**5 Merrill Street**

Dear Christina Stacey (Zoning Specialist),

I am an abutter of the proposed building site at 5 Merrill Street.

BUILDING SECTIONS

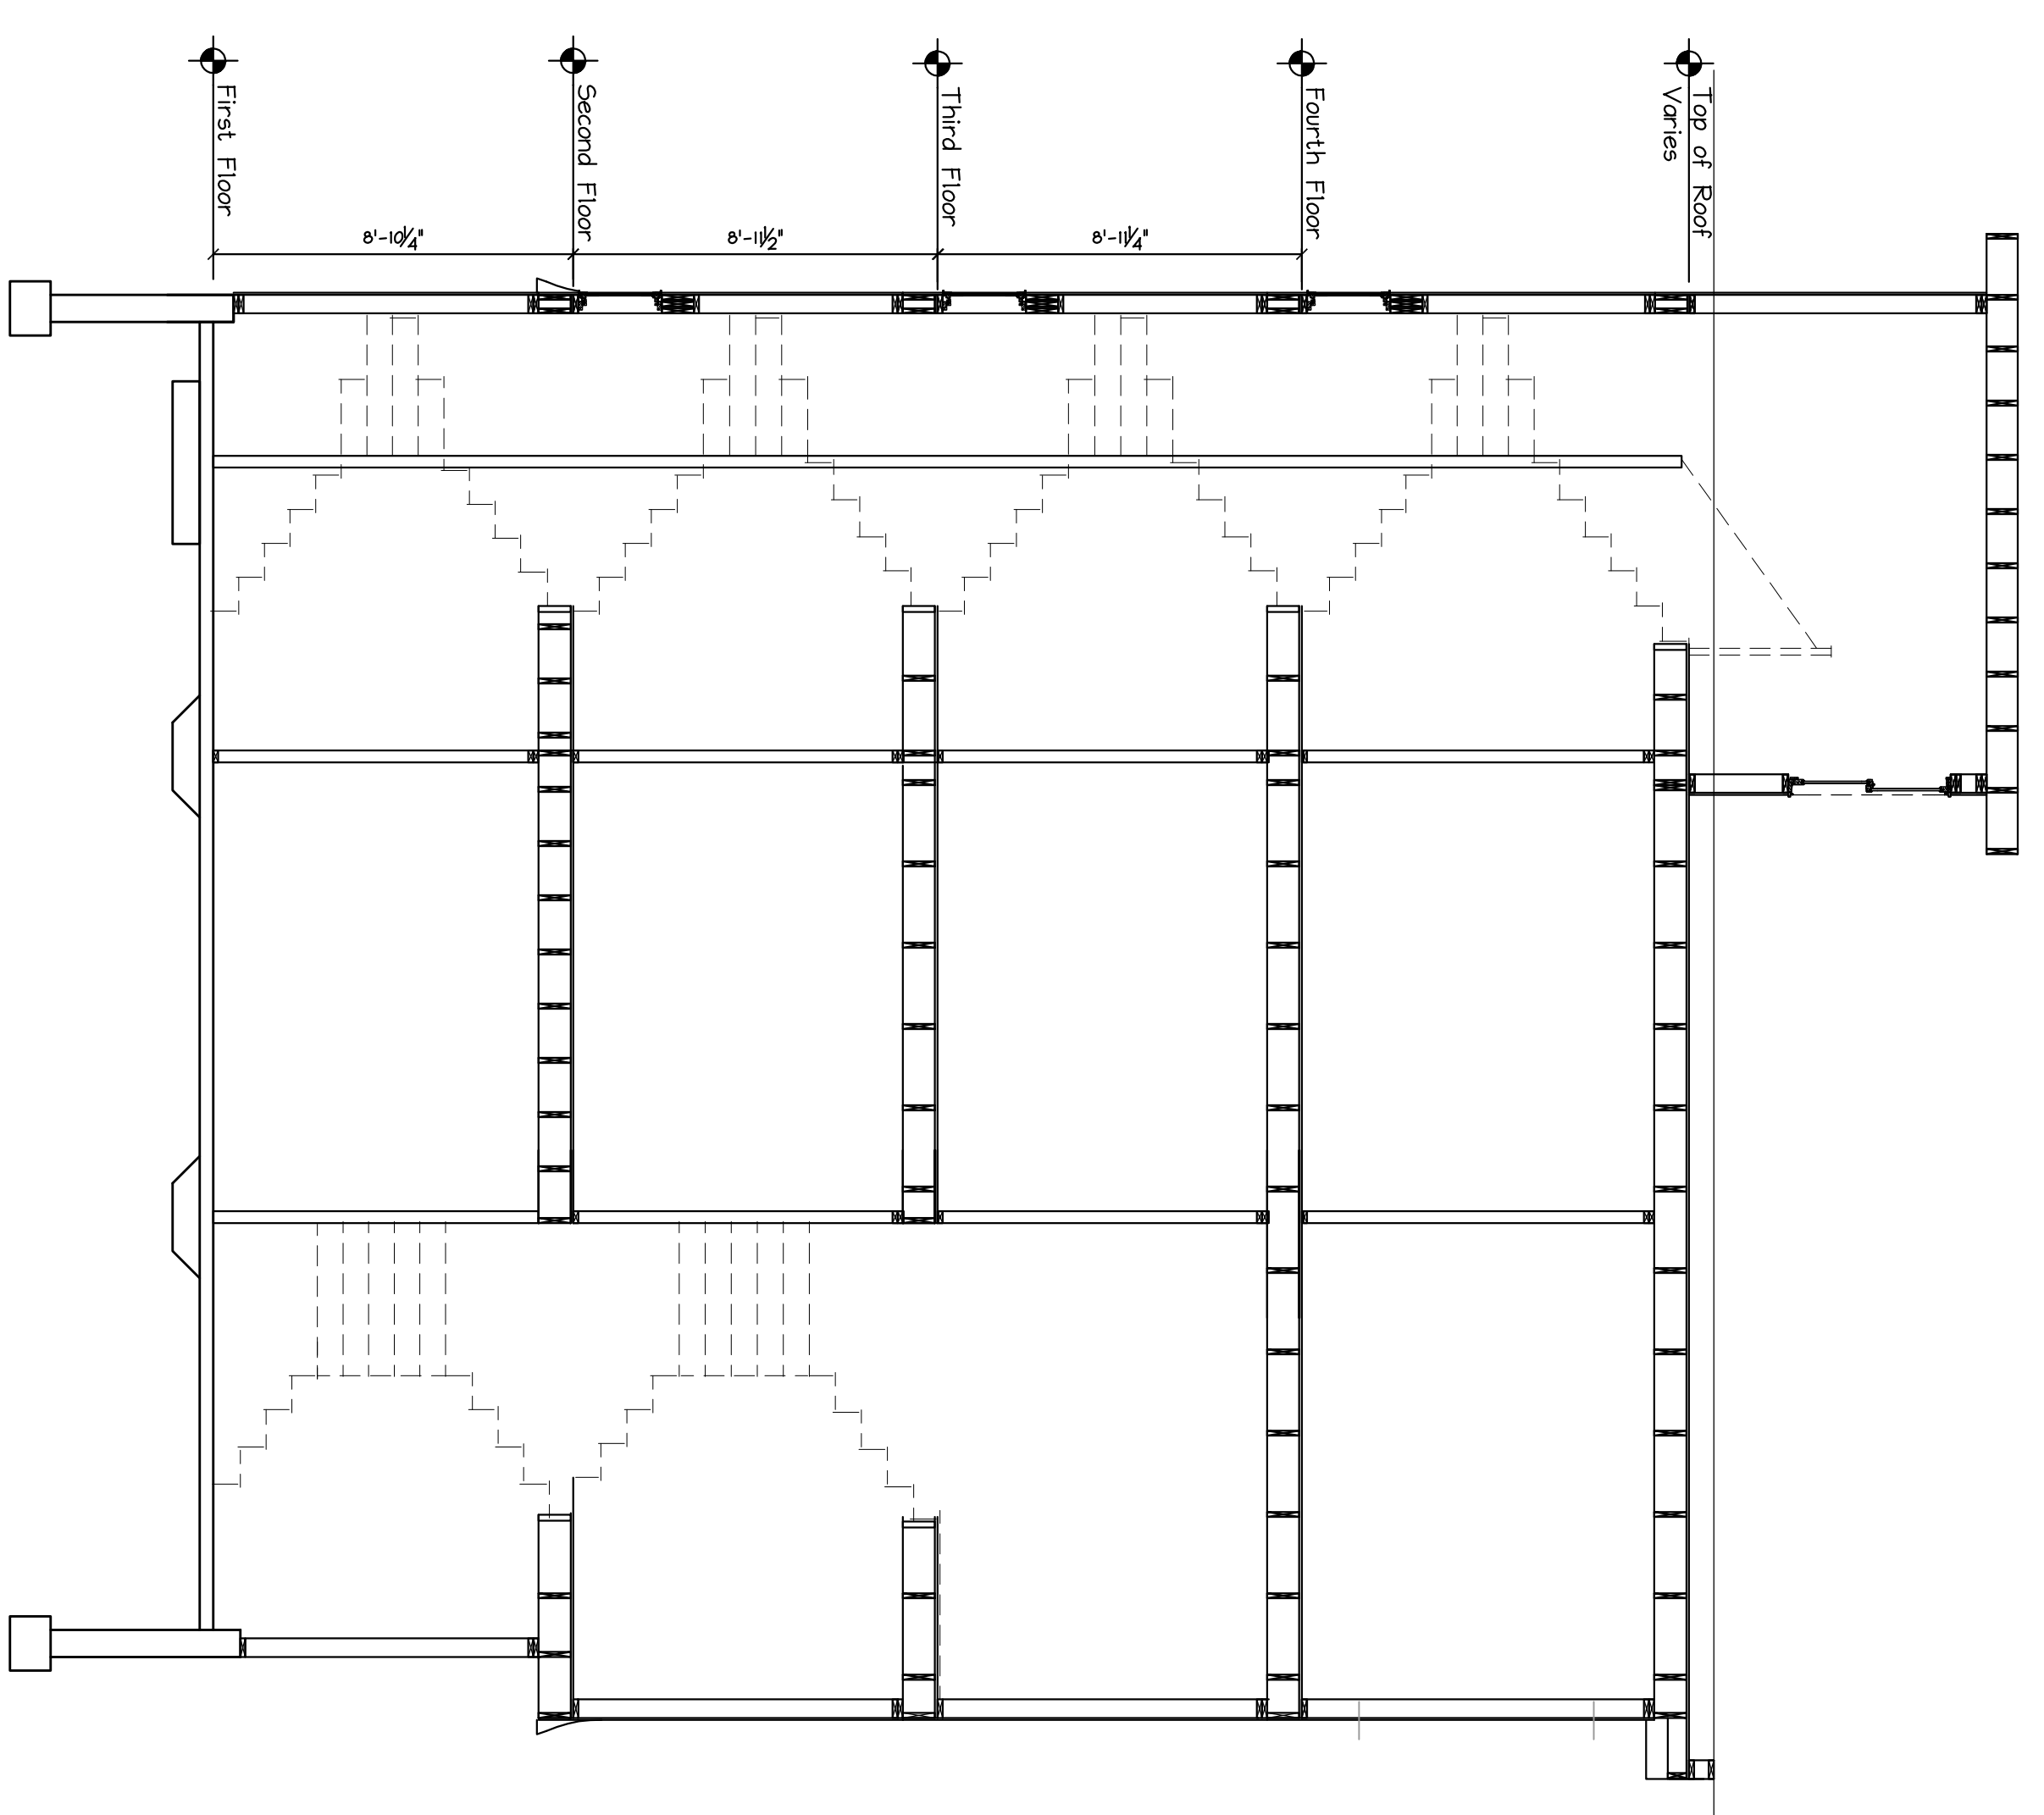
I was very surprised to see preliminary plans for such a high imposing building on such a small lot. The prior building was the same height as my adjoining building.

This new building proposal is clearly going to overhang and threaten the privacy of my buildings located directly on the next lot at 77-79 Congress Street.

My three buildings have stood here for years and my tenants are extremely concerned about their exposure of a 4 story balcony/deck overlooking their home, gardens and lives.

Please, can we scale this project back a bit?

Thank you for your comments on this project. I have not yet started to review the plans, but I can assure you that we will thoroughly examine the project to ensure that it meets all zoning requirements. The property is located in the R-6 zone which does allow structures up to 45 feet in height, with "step-backs" starting at 35 feet. The zoning regulations were adopted by city council and we are obligated to apply them equally to all projects.
